From:
Sent: 03 March 2024 11:06
To: Planning ContactCentre
Subject: Objection to planning application 2024/90273
Attachments: planning 202490273.docx; fwphotos.zip

Planning Application Ref: 2024/90273

Description: Erection of Two Semi-Detached Dwellings

DRAWING TITLE
Site Block Plan
REV 01

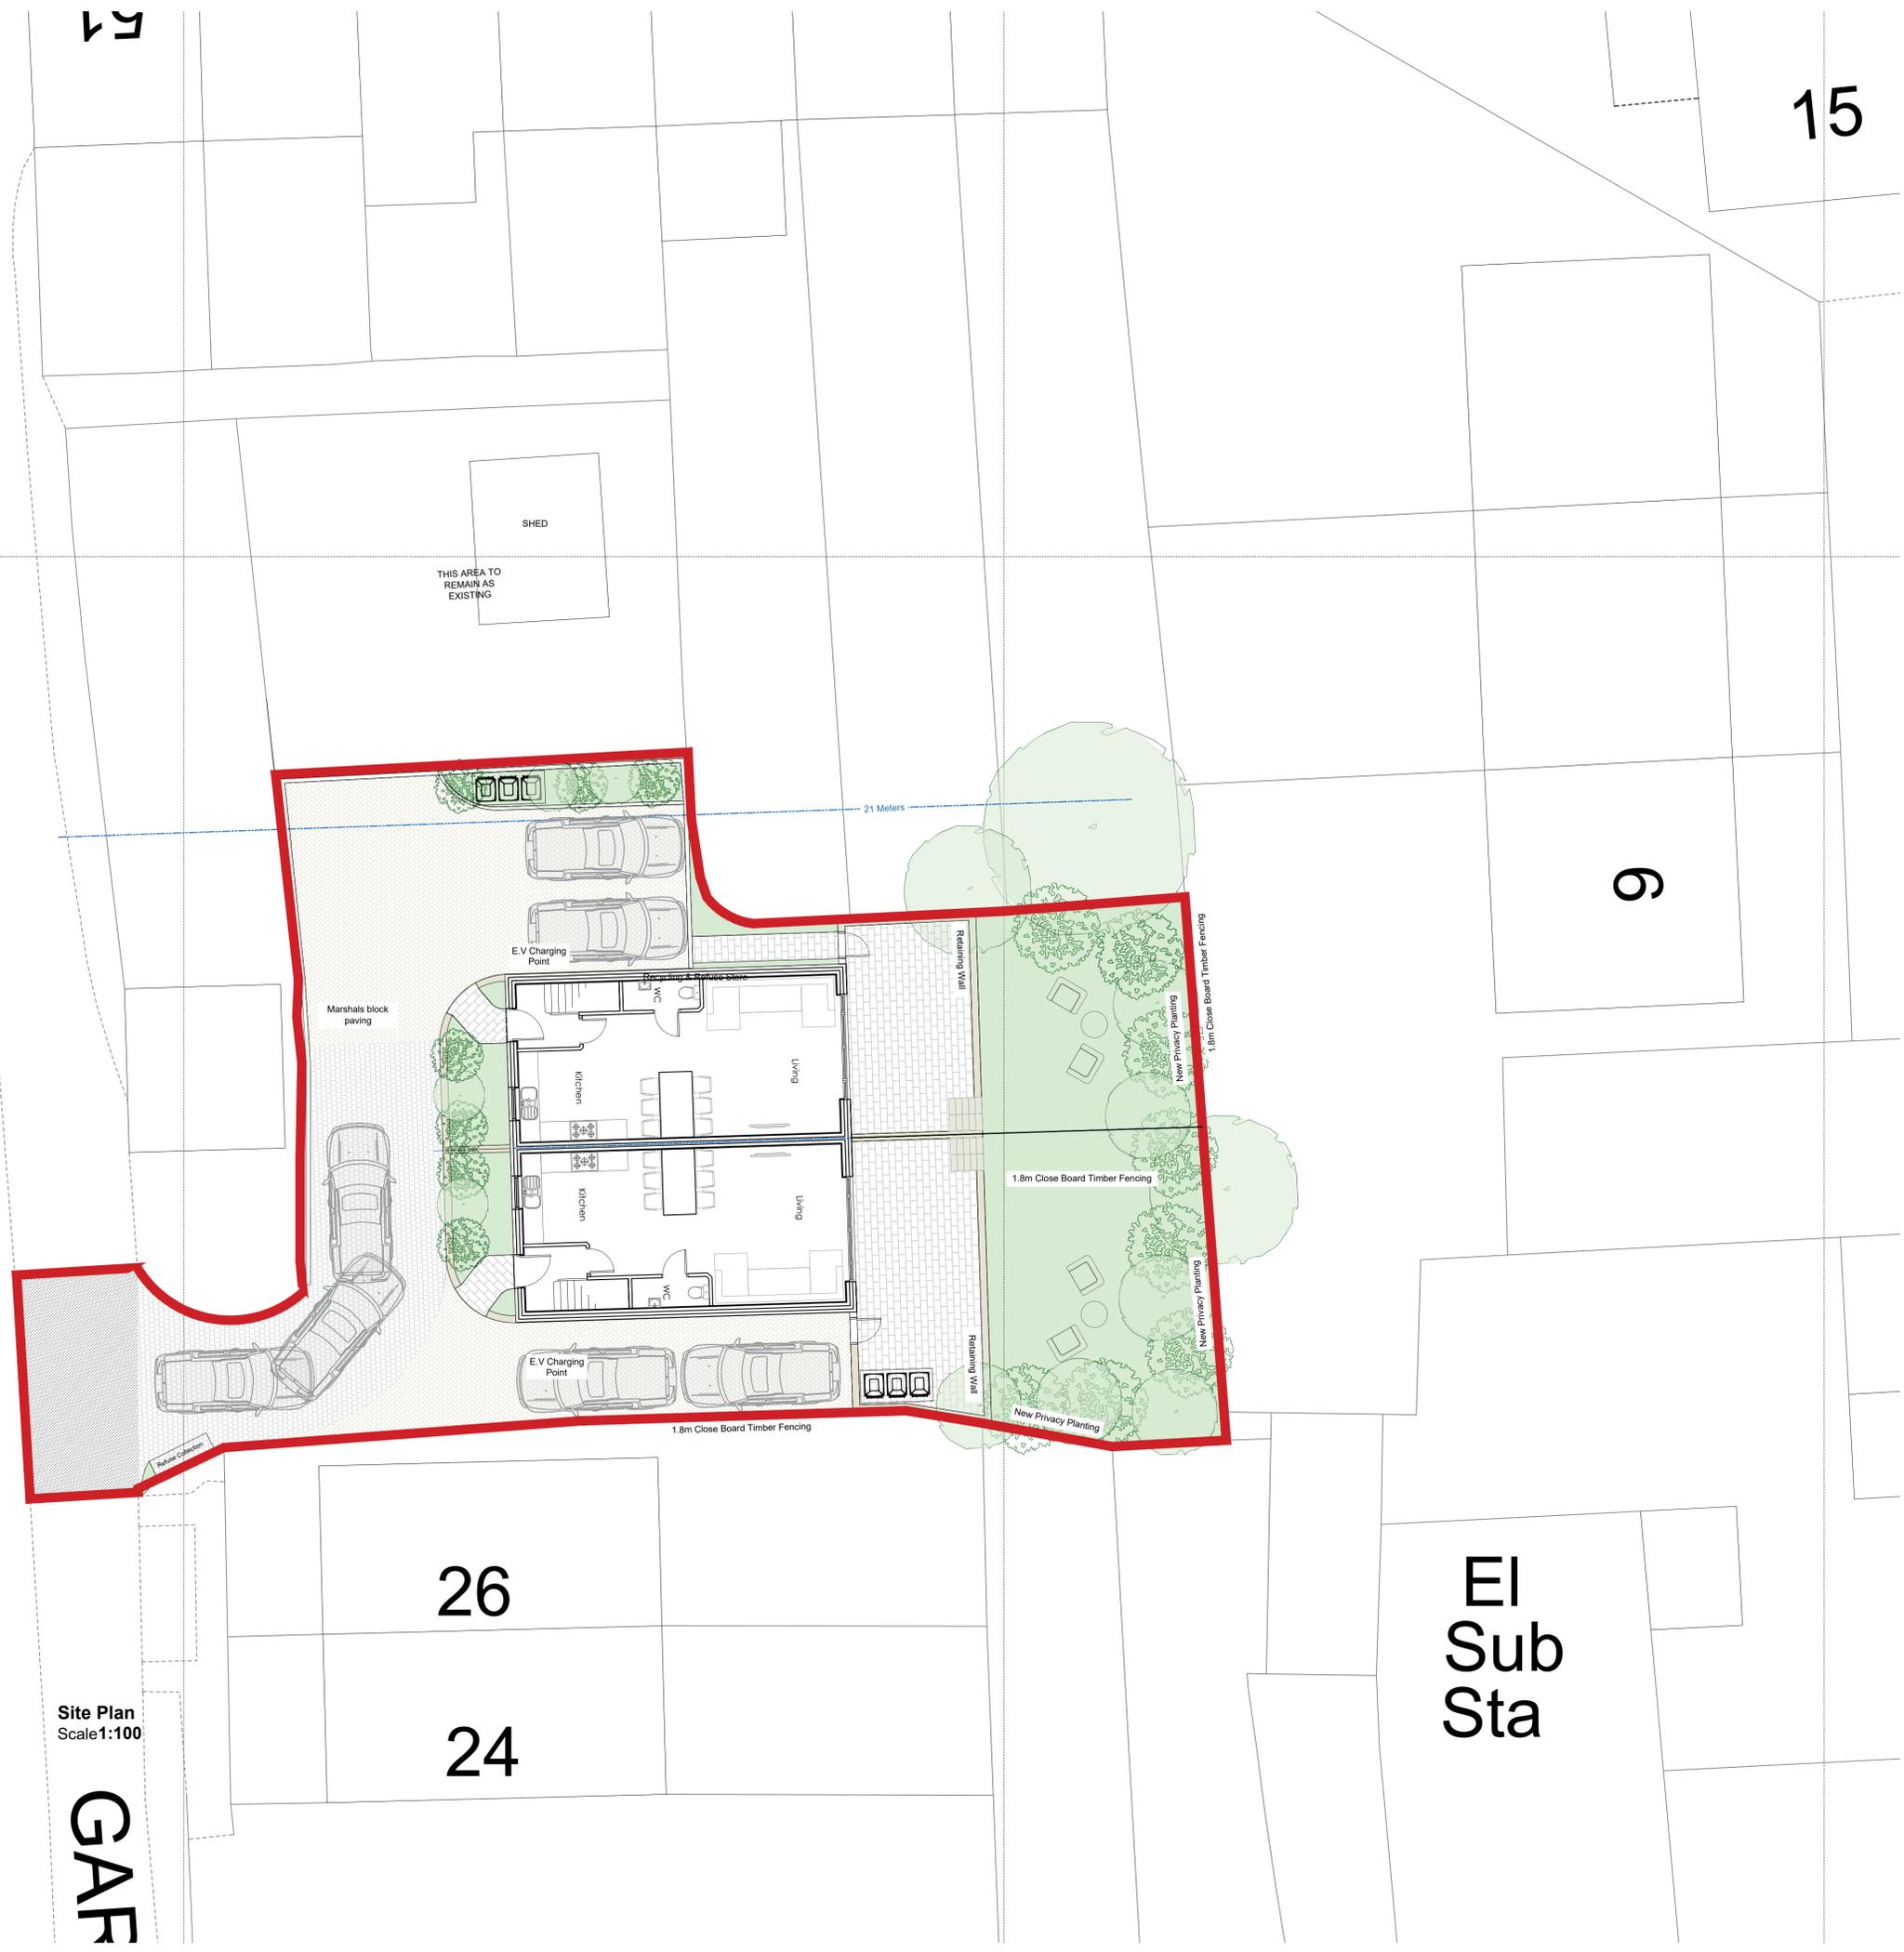
1. The boundary lines in the proposed development plan are incorrect. The garages proposed are on the land owned by 53 Garden Place. We feel this is a misrepresentation of proposed development plans and their boundaries. True boundary lines marked – see Diagrams A/B
